From: Paul Voller [REDACTED]
Sent: 11 May 2021 17:43
To: Simon Davis <Simon.Davis@arun.gov.uk>
Cc: Joanne Lewis <Joanne.Lewis@arun.gov.uk>
Subject: Re: Tars Farm BN/41/21/DOC

As discussed, the Environmental Health Officer has raised 6 points which are addressed in turn below.

Site Plan showing Measurement Positions (Appendix 2, Figure 1):

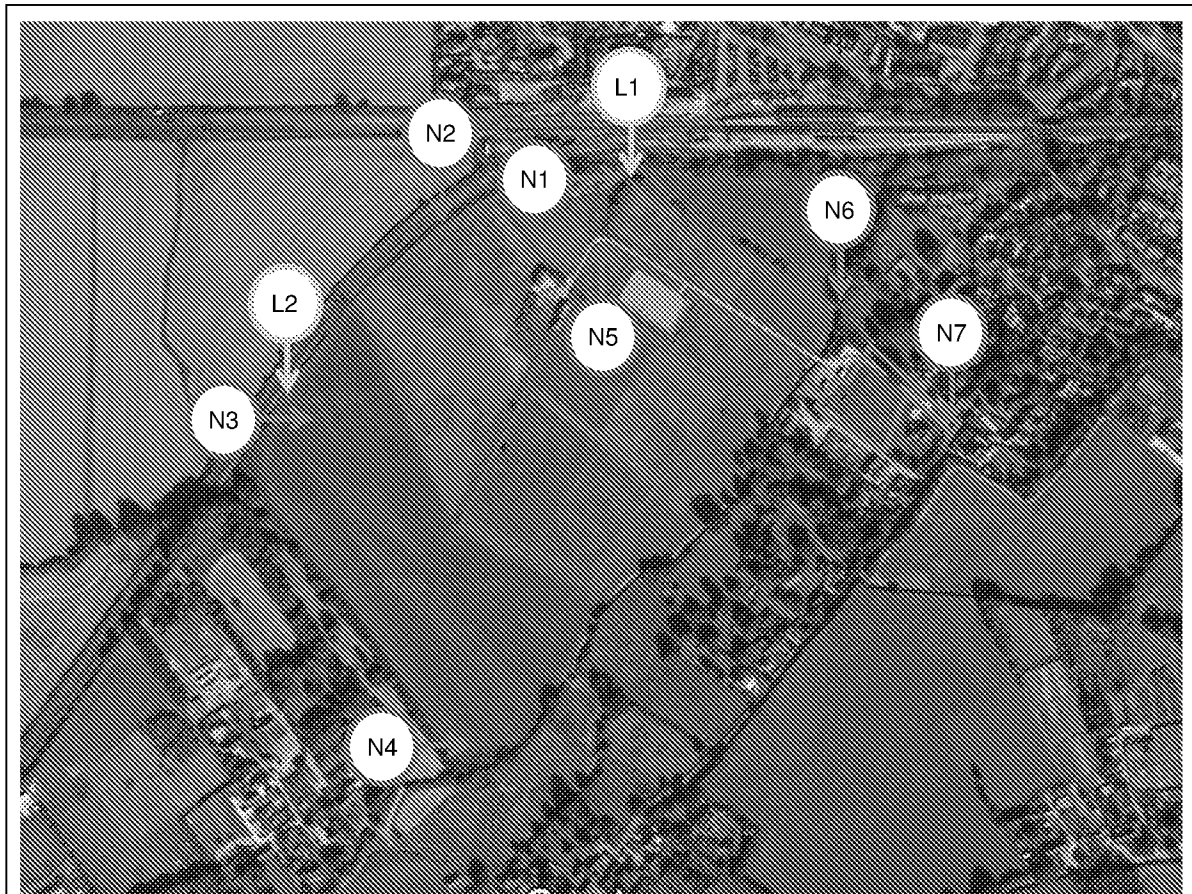
1. (and 2.) Loggers were positioned close to the railway which is the noise source identified in the planning condition. The results were distanced corrected to determine noise levels at the site which is common practise within the industry. Attended measurement supplement the unattended measurements to gain spectral data surrounding the site. Attended measurements also allow us to form an objective opinion of the site. Train noise impinging on the site is described in Appendix 2 as distant and quiet at the attended locations.

The length of measurements is to the acousticians discretion, depending on the purpose of the measurement and what is dictating the noise. For example, you would take much shorter measurements to capture an individual train pass than you would to capture background noise levels. In this case, the 4 minute measurements have captured train noise on site suitably and we are confident the survey and results accurately represent the acoustic environment on site.

3. Noise survey results at the northern edge of the site relate to the distance corrected values of logged data. Section 3.9 states the noise levels are at a distance of 170m from the nearest railway tracks - nearest dwelling in the development. Logged positions were approximately 3.5m from the track (Appendix 2), assuming the trainline acts as a line source, the noise level will decay by 3dB per doubling of distance. For maximum noise levels, this will decay by 6dB per doubling of distance. The data from logger position L2 was used in our calculations as this was the higher of the two logging results.
